Recommendation Report for Planning Permission for Works or Extension to a Dwelling

REF NO: BR/15/21/HH

LOCATION: 32 Murina Avenue
Bognor Regis
PO21 2DA

PROPOSAL: Two storey rear extension and balcony.

CLIENT	Mrs A Field	
SITE	32 Murina Avenue, Bognor Regis, West Sussex	
PROJECT	Proposed Extensions & Alterations	
DRAWING	003 Proposed Plans & Elevations	
DATE	18 01 21	
AUTHOR	AH	REVISION
STATUS	PL	
SCALE	1: 100 @ A3

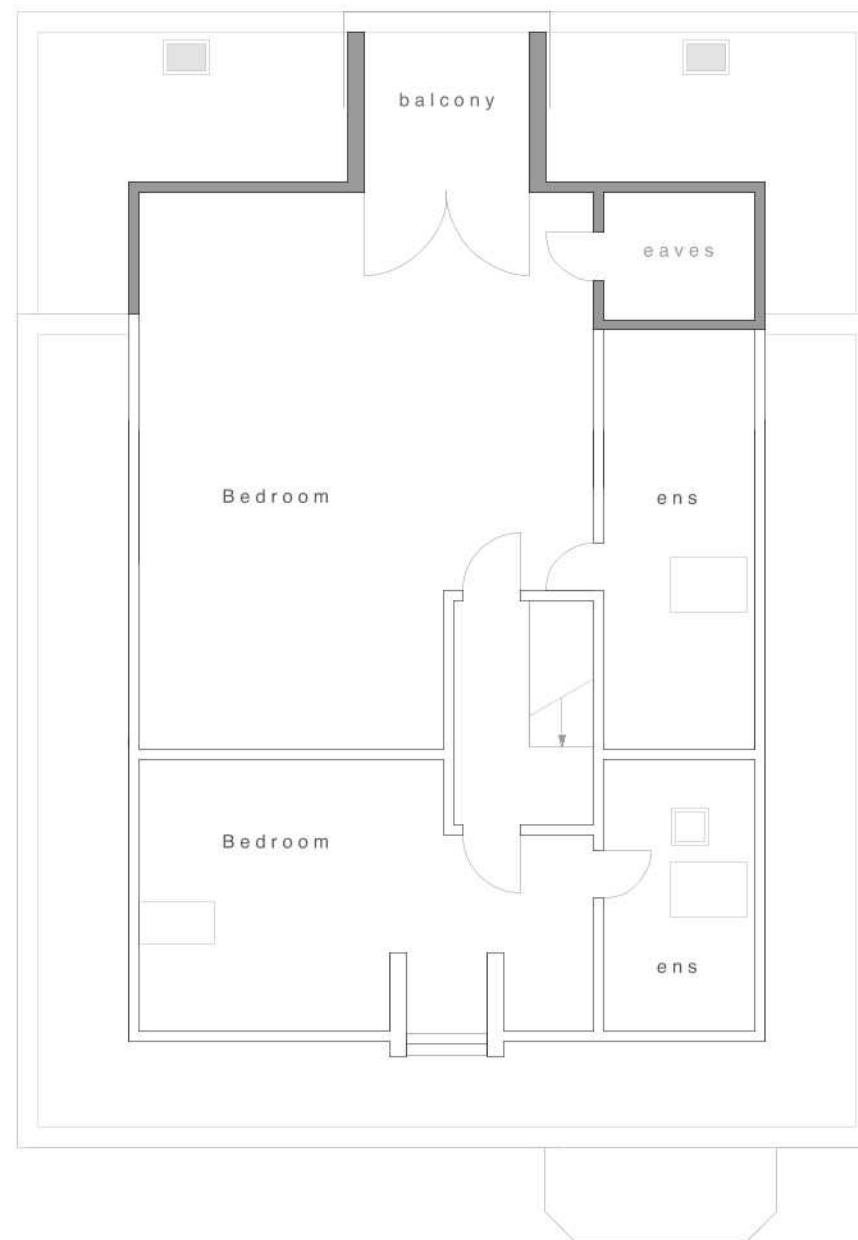
- Internal change from utility to bathroom
- Increase in the pitch of the roof by 30cm.
- Increase number to ground floor windows.

There will be an additional window to both ground floor side elevations. As these are to the ground floor and with sufficient separation to the boundaries with fencing in place, it is not considered this will give rise to adverse overlooking.

CLIENT	Mrs A Field	
SITE	32 Murina Avenue, Bognor Regis, West Sussex	
PROJECT	Proposed Extensions & Alterations	
DRAWING	004 Proposed Plans & Elevations	
DATE	18 01 21	
AUTHOR	AH	REVISION
STATUS	PL	
SCALE	1: 100 @ A3

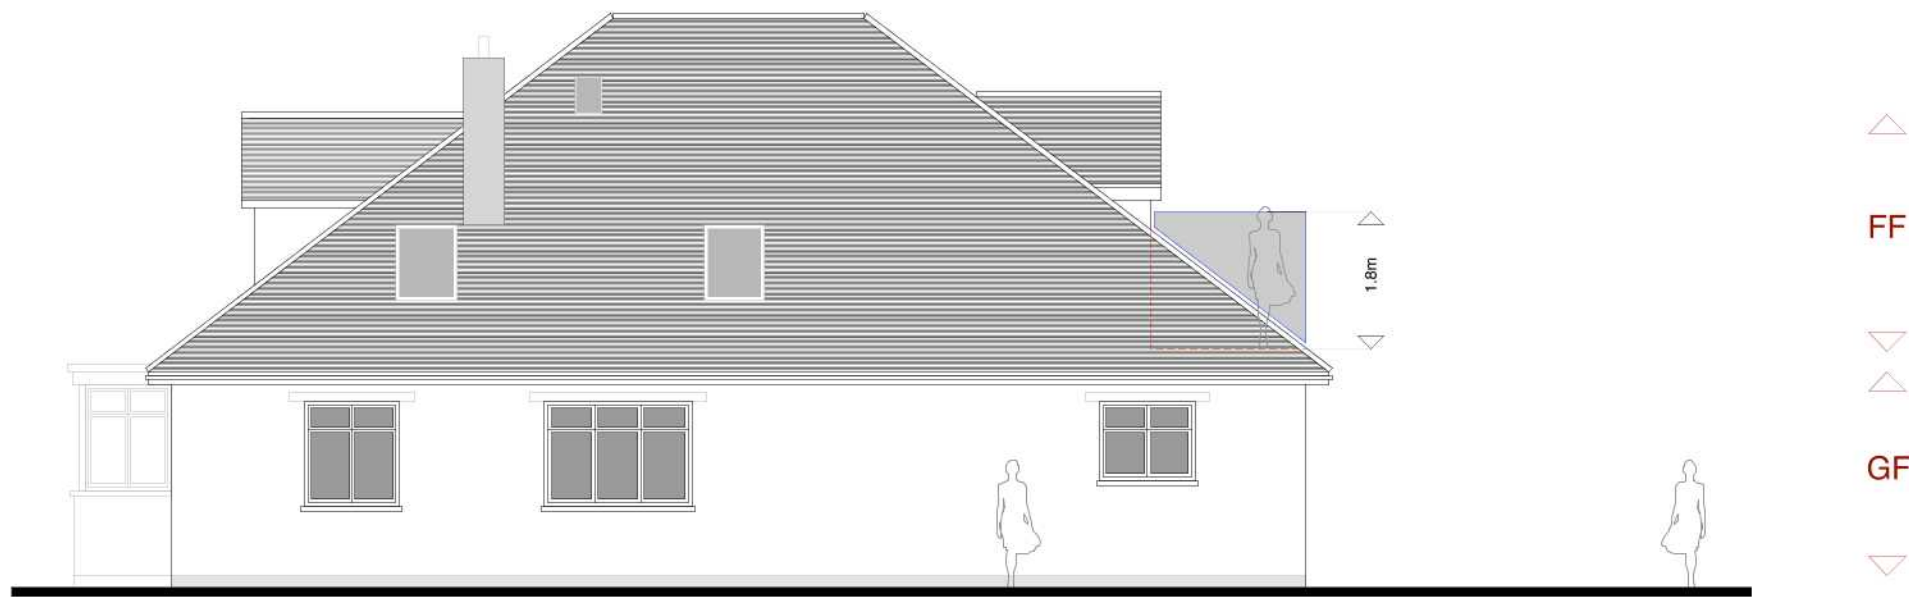
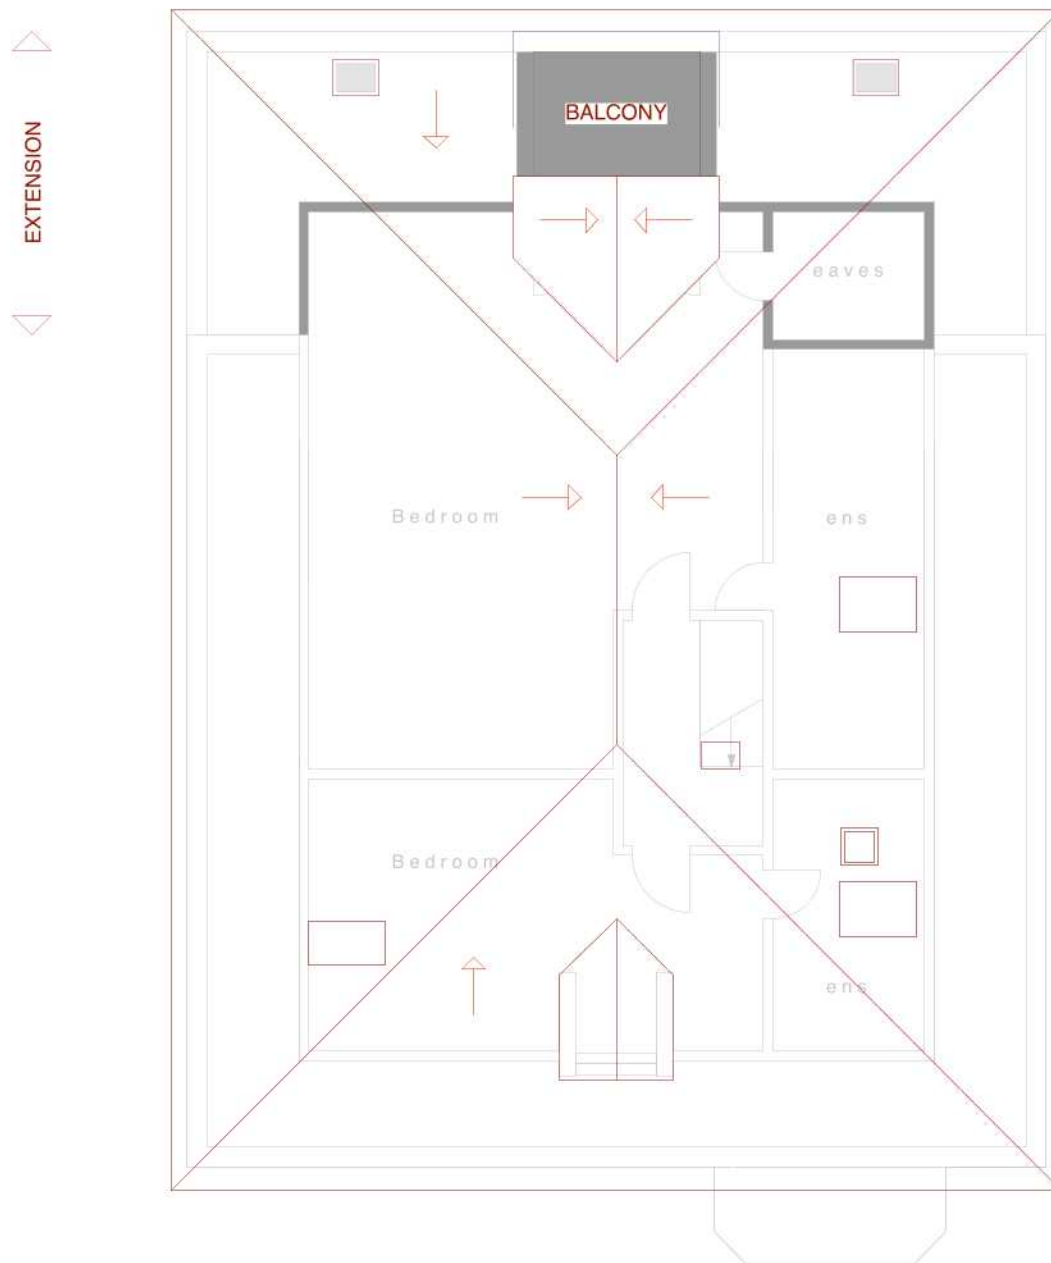
The property is a detached chalet bungalow and the roof will run up to a point to form a small pitch and therefore it will increase in height by 0.3m to 7.6m.

The street scene consists of properties that are mixed in appearance and the alterations are not considered to result in the property appearing out of character in the area, with the height remaining similar to those within the street scene. The roof remains hipped and therefore the increase in height is not considered to appear unduly dominant.

The height of the dwelling will increase around 0.3m however with the roof hipped and with 2.8m and 4.5m retained to the neighbouring boundaries, this is not considered to result in adverse overbearing or overshadowing upon amenity.

- 3 The balcony screening to the north west and south east side elevations of the balcony shall at all times be obscured glazed and to a height of 1.8m and be retained thereafter in perpetuity.
